From: Liz Annalls [REDACTED]
Sent: 01 October 2020 10:53
To: Planning.Responses <Planning.Responses@arun.gov.uk>
Subject: RE: Planning Consultation on: BE/92/20/DOC

App No: BE/92/20/DOC
Address: Babsham Business Centre Babsham Lane Bersted PO21 5EL
Proposal: Approval of details reserved by condition imposed under ref
BE/89/19/PL relating to Condition Nos 2 - car parking spaces, 3 - acoustic
assessment, 4 - mitigation & remedial strategy for reptiles, 11 - access
road, 12 - bat boxes and 13 - dust control

DRAWING TITLE
SITE IDENTIFICATION PLANS
SITE LAYOUT PLAN
STORAGE CONTAINER DETAILS

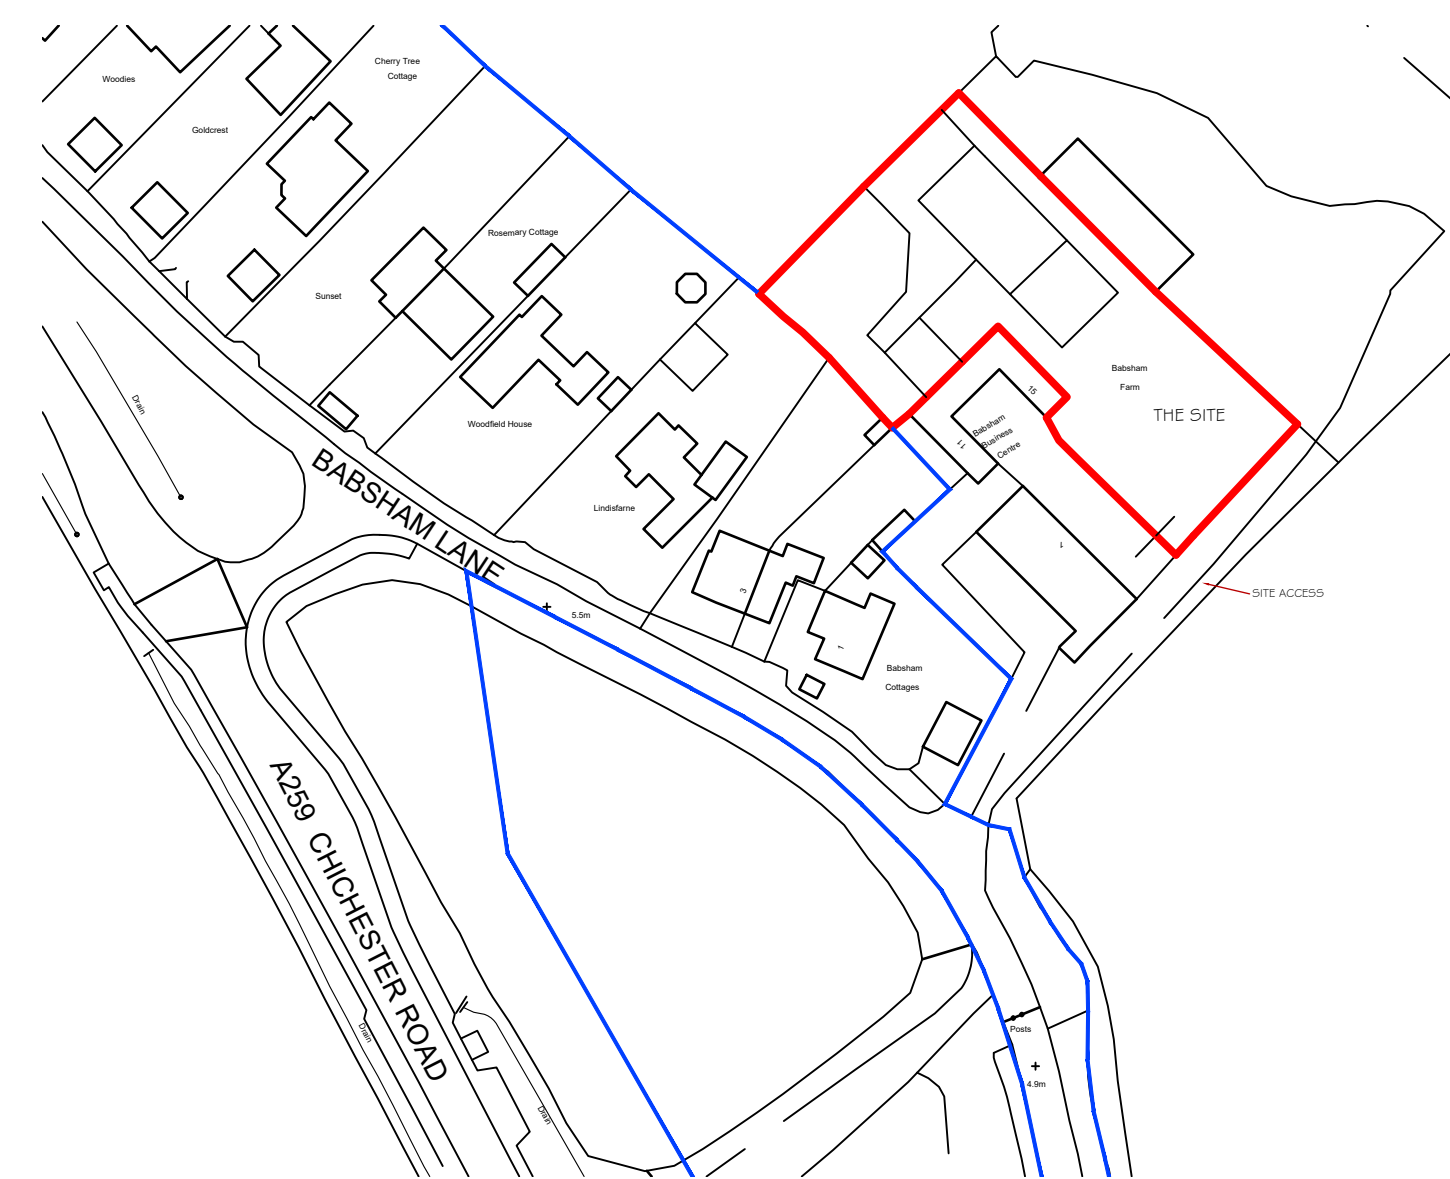
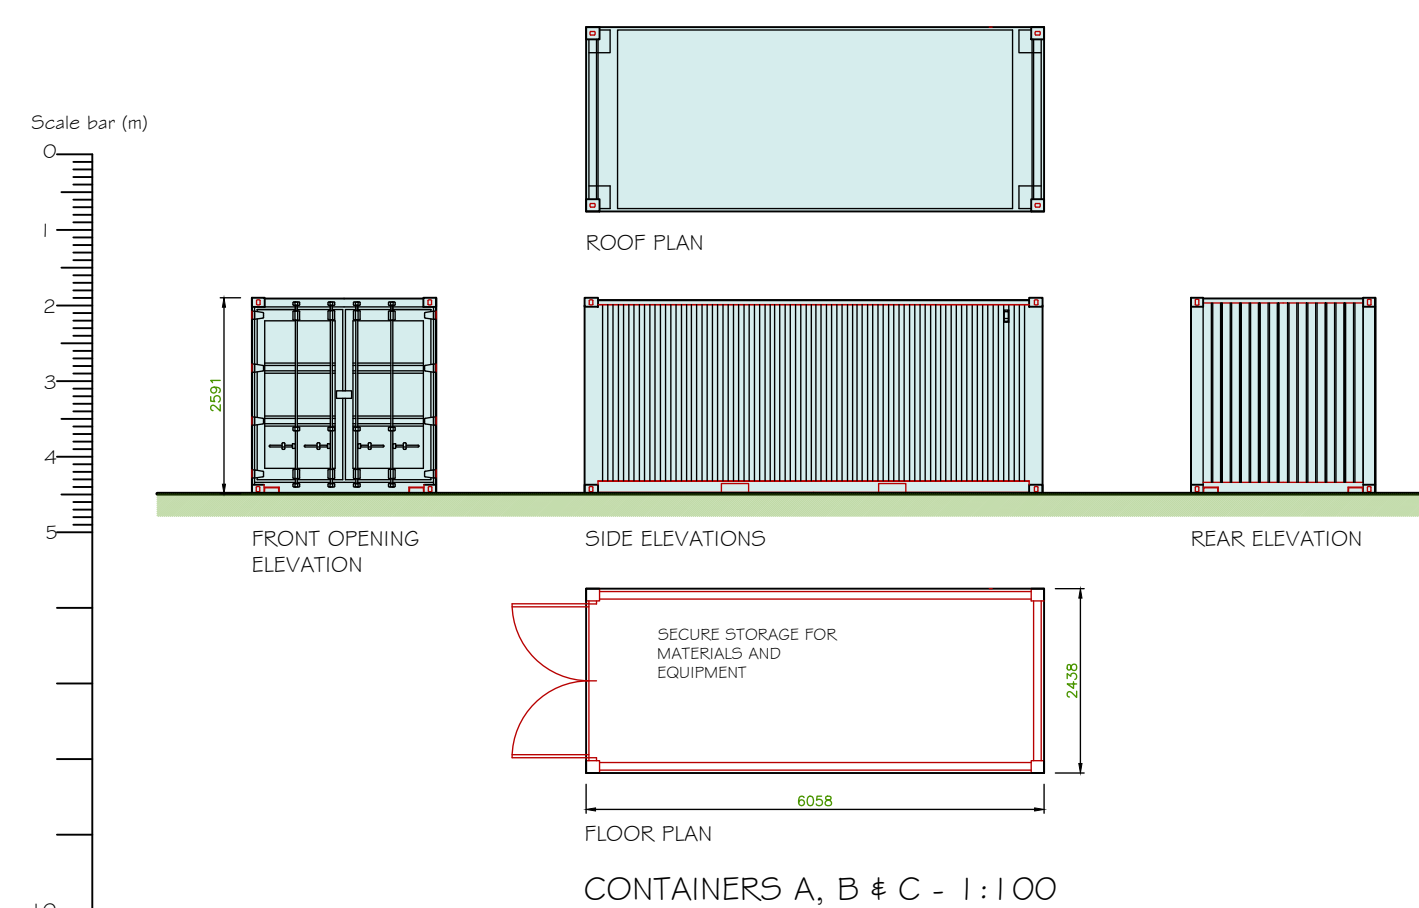
Following submission of the SITE IDENTIFICATION PLANS SITE LAYOUT PLAN STORAGE CONTAINER DETAILS plan we are satisfied that no further information is required relating to this.
